C: [REDACTED]
Subject: Bonhams Field RM - Submission of updates Tree Protection Plan for Consistency with Landscape Plans Y/63/19/RES

I have amended conditions 1 and 2 to reference the correct plans. The 18076-P110 Rev B was a typo on my part (we have the Rev B on file). The Rev B Tree Protection Plan was not previously supplied to us so I will get it added tomorrow.

scheme: Bonhams Field
Yapton
client: Seaward Properties Limited
drawing: Tree Reference Plan
date: August 2016
scale: 1:500@A1
dwg no: SEA20727-03A
drawn: RA checked: MW

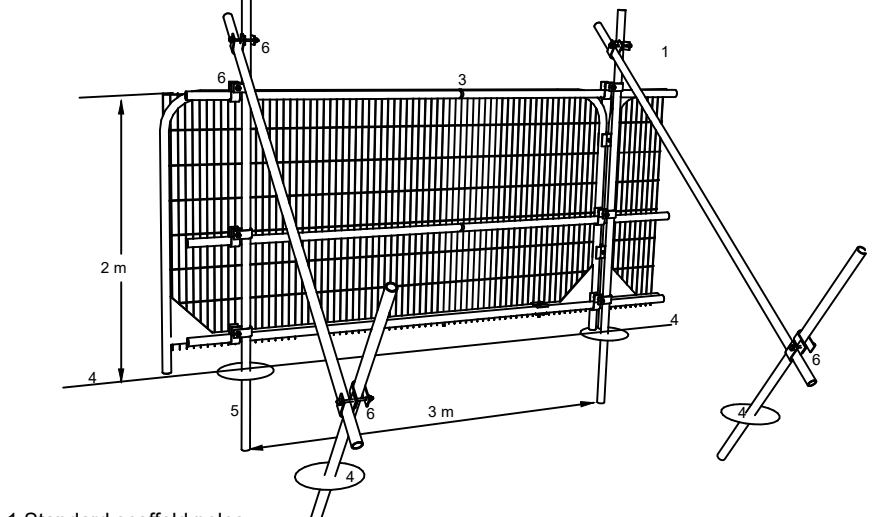
"Tree Reference Plan" ref SEA20727-03A (12.12.19) needs to be updated to show the small section of hedgerow next to the orchard for removal, as agreed with the PC and shown on the approved landscape plans also listed in Condition 2. This is for consistency. I have asked our arboricultural consultant to send over a copy.

Please find attached updated Tree Protection Plan showing the agreed removal of the short section of hedgerow, for consistency with the approved landscape plans. The AIA & Method Statement has been updated to reflect this, for completeness.

“Tree Reference Plan” ref SEA20727-03C (21.02.20)
“Arboricultural Impact Assessment and Method Statement” (ref: SEA20727aia-ams, Rev: B, 21/02/20)
